**20.2 MAJOR PROJECT MP09\_0066 MODIFICATION 3 – ALBERT AVENUE/THOMAS STREET, CHATSWOOD (CAR PARK SITE) SUBMISSION TO THE DEPARTMENT OF PLANNING**

**SUBMISSION BY WILLOUGHBY CITY COUNCIL ON PROPOSED MODIFICATION 3 OF THE APPROVAL MP09\_0066 FOR THE SITE KNOWN AS THE THOMAS STREET CAR PARK SITE IN CHATSWOOD**

**SWEPT PATH ANALYSIS
OF A 10.2m REFUSE
VEHICLE ENTERING THE SITE**

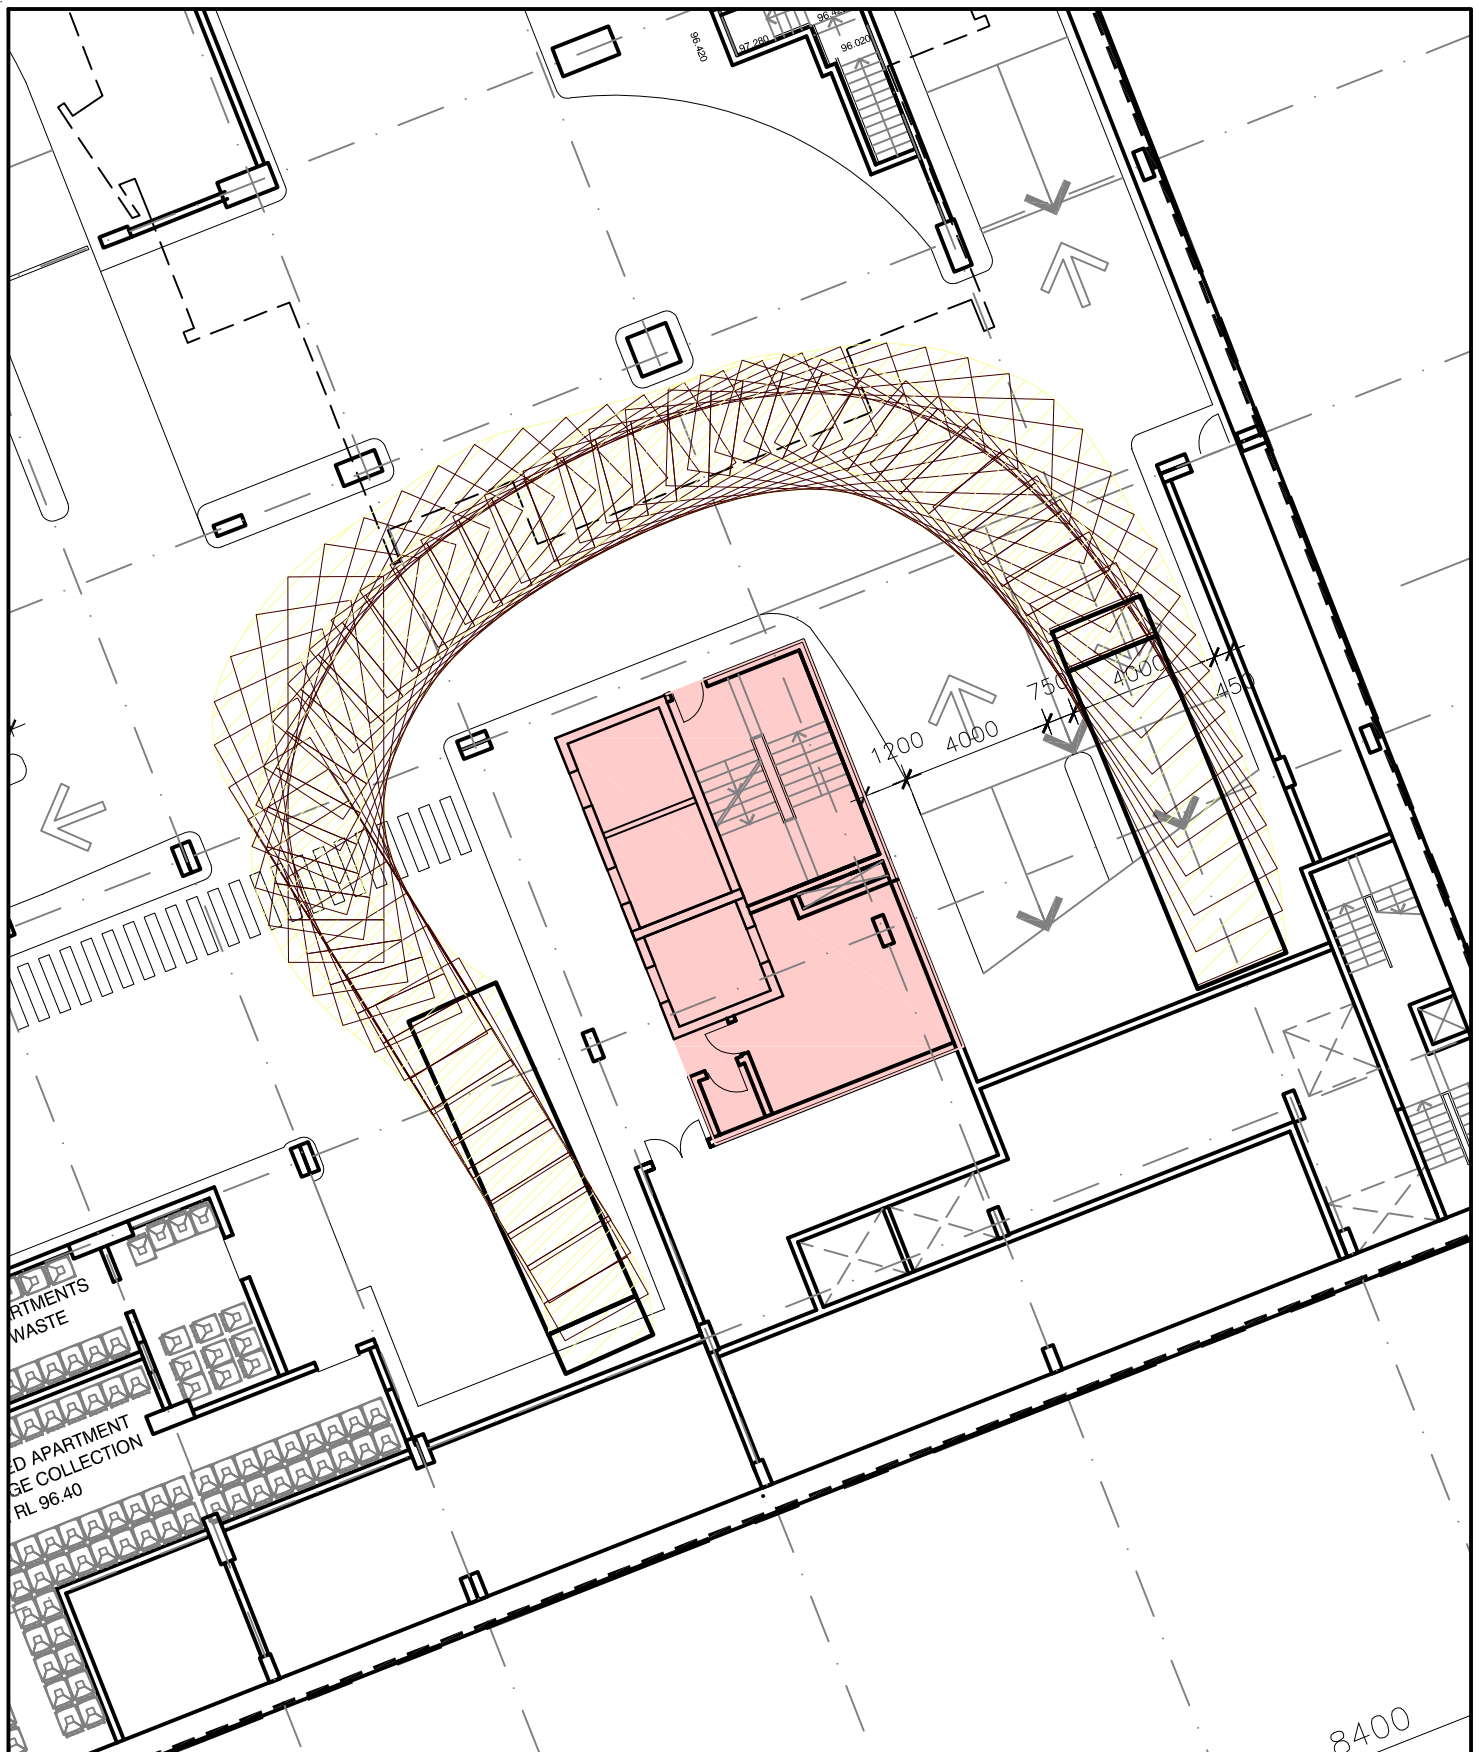
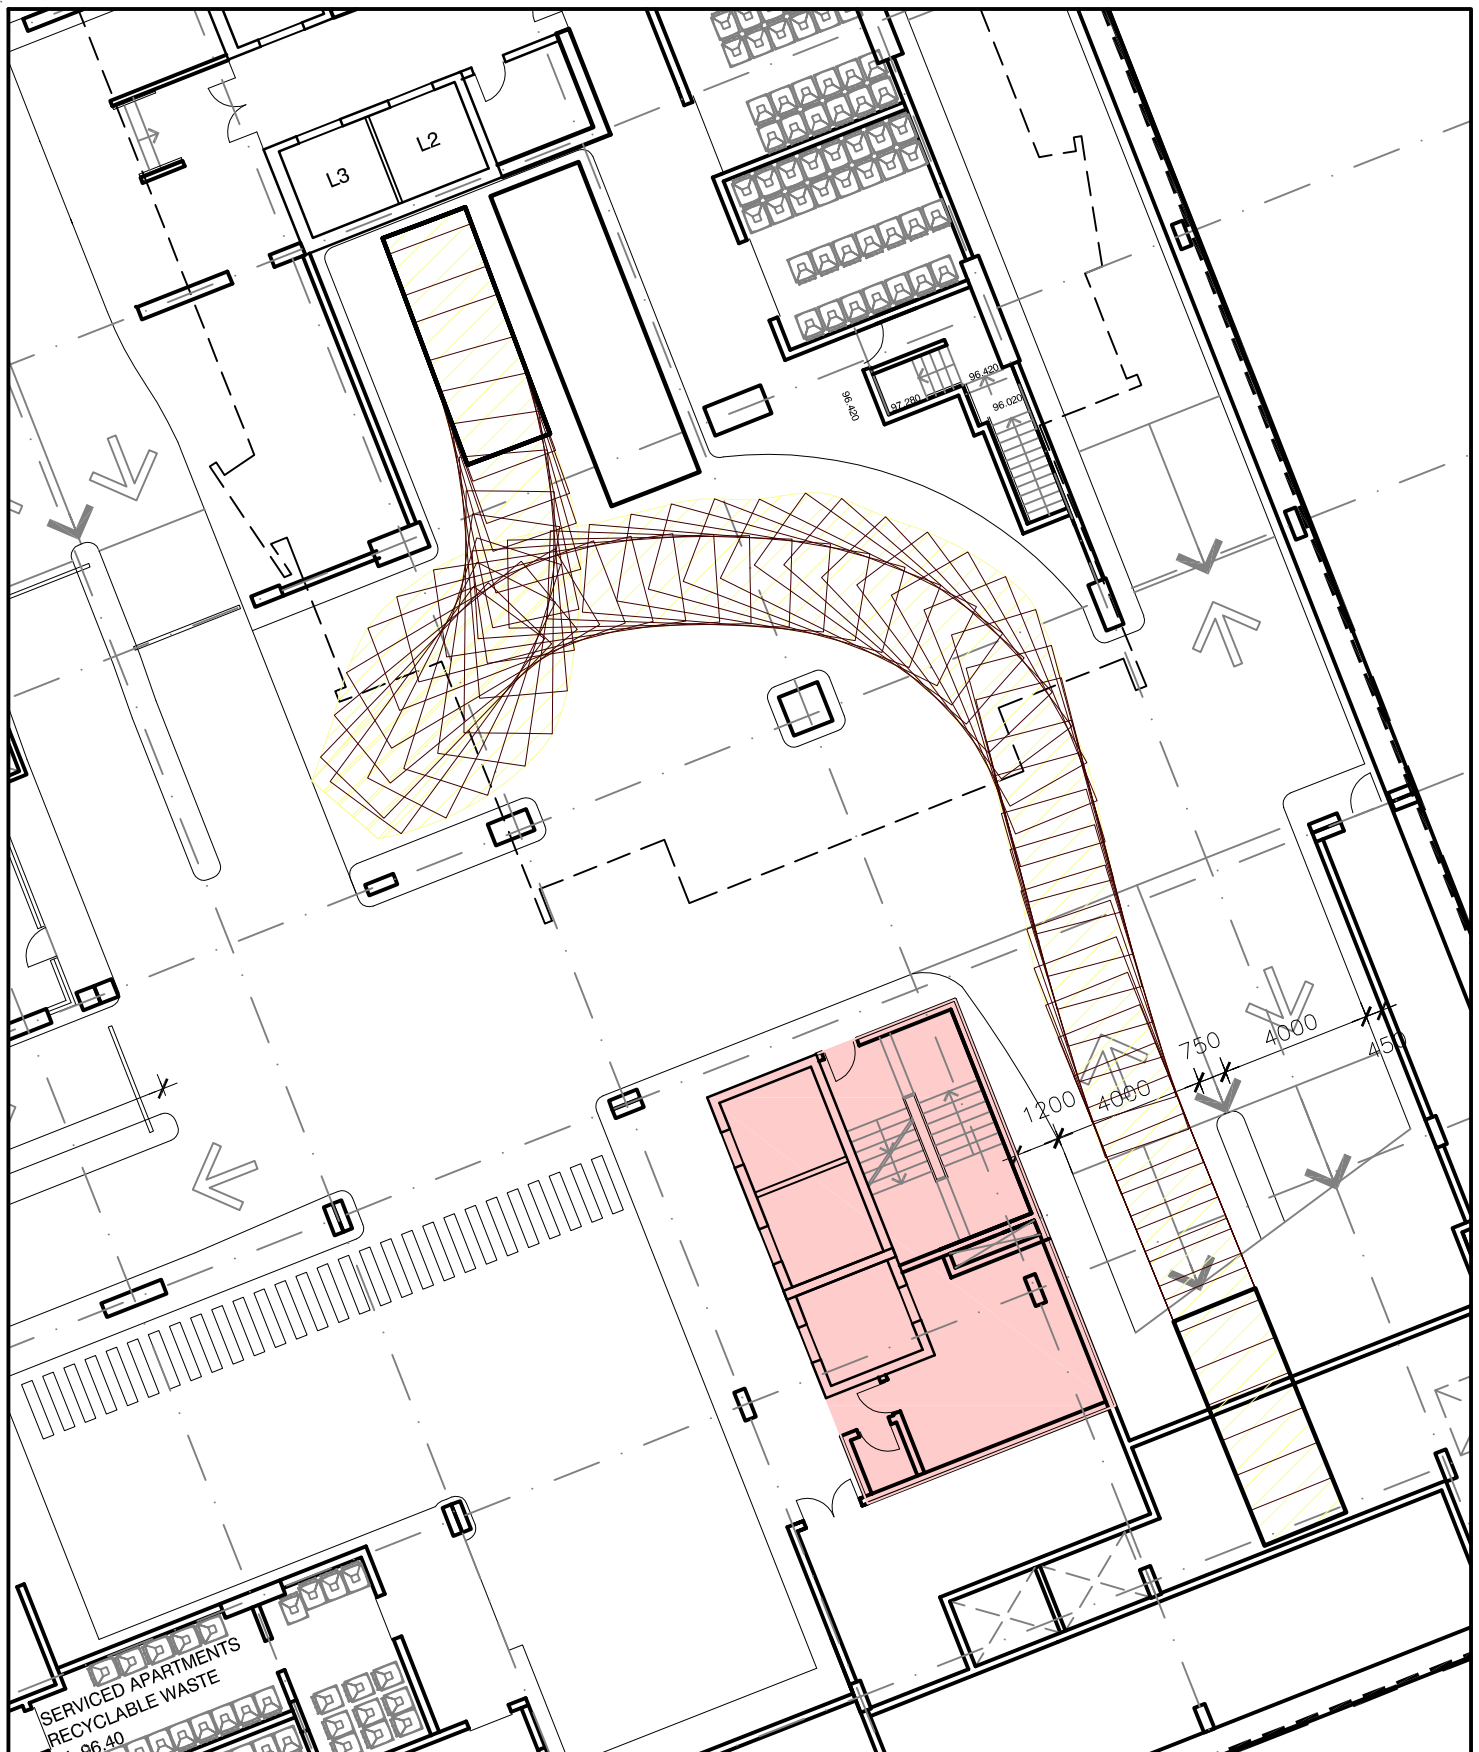
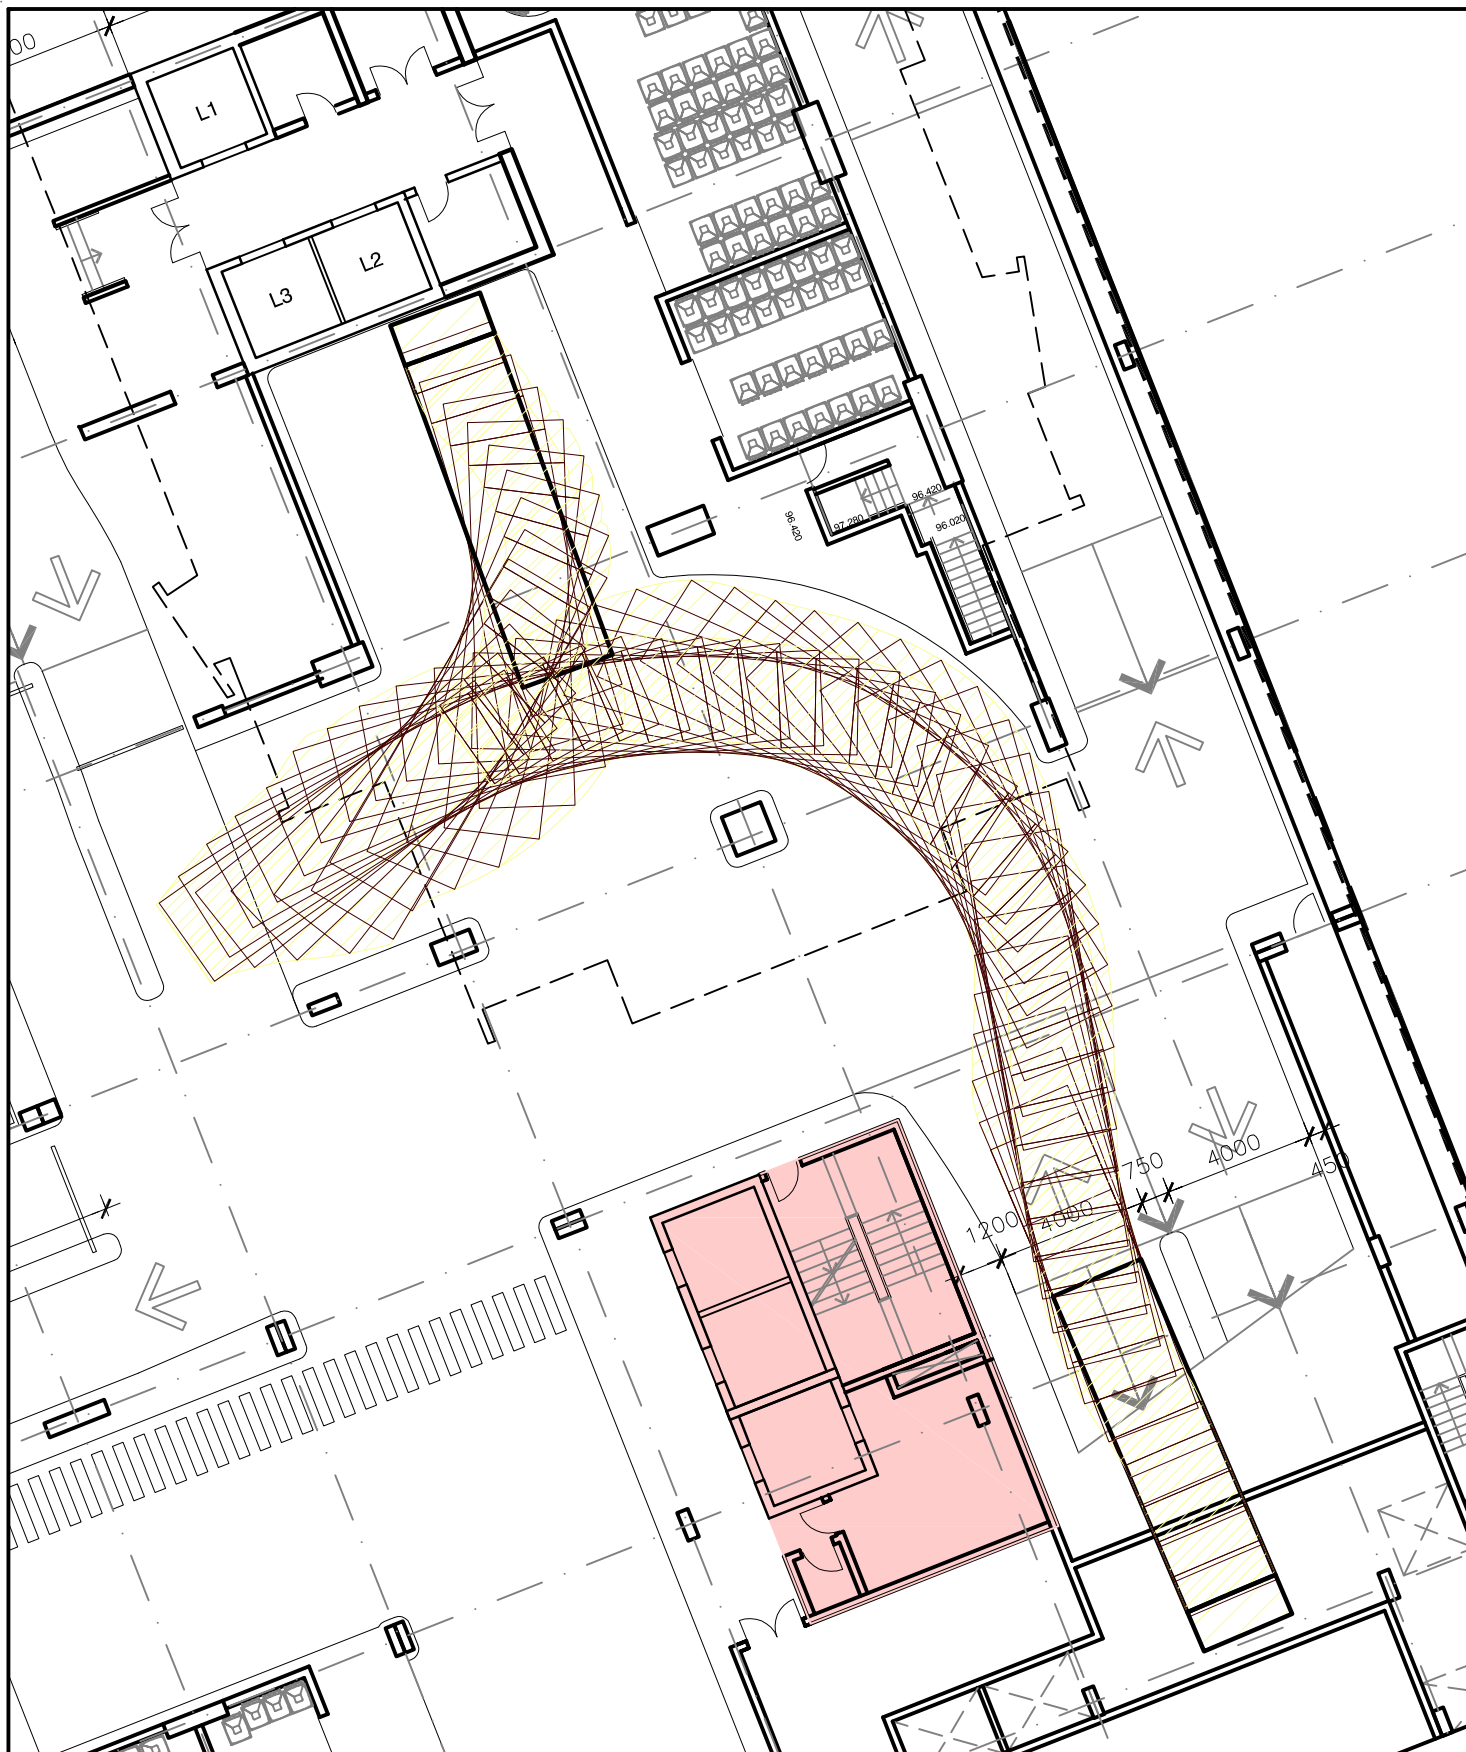
- f) Council in the original application has previously raised concern regarding the design of the loading docks and manoeuvring of trucks. The amended design provides separated area from the circulating aisles for manoeuvring that is an improvement from the original design. However, the short term spaces for couriers have been removed and column positions require precision driving by trucks accessing the loading docks. One medium rigid (8.8 metres) and one small rigid truck are the maximum capacity of the two loading docks. When a 10.2m truck is using the loading

dock manoeuvring space precludes the ability for the truck to position itself to allow use by another truck. It is noted that the size of garbage vehicle that is used by Council for residential buildings of the proposed scale is the 10 metre medium rigid trucks.
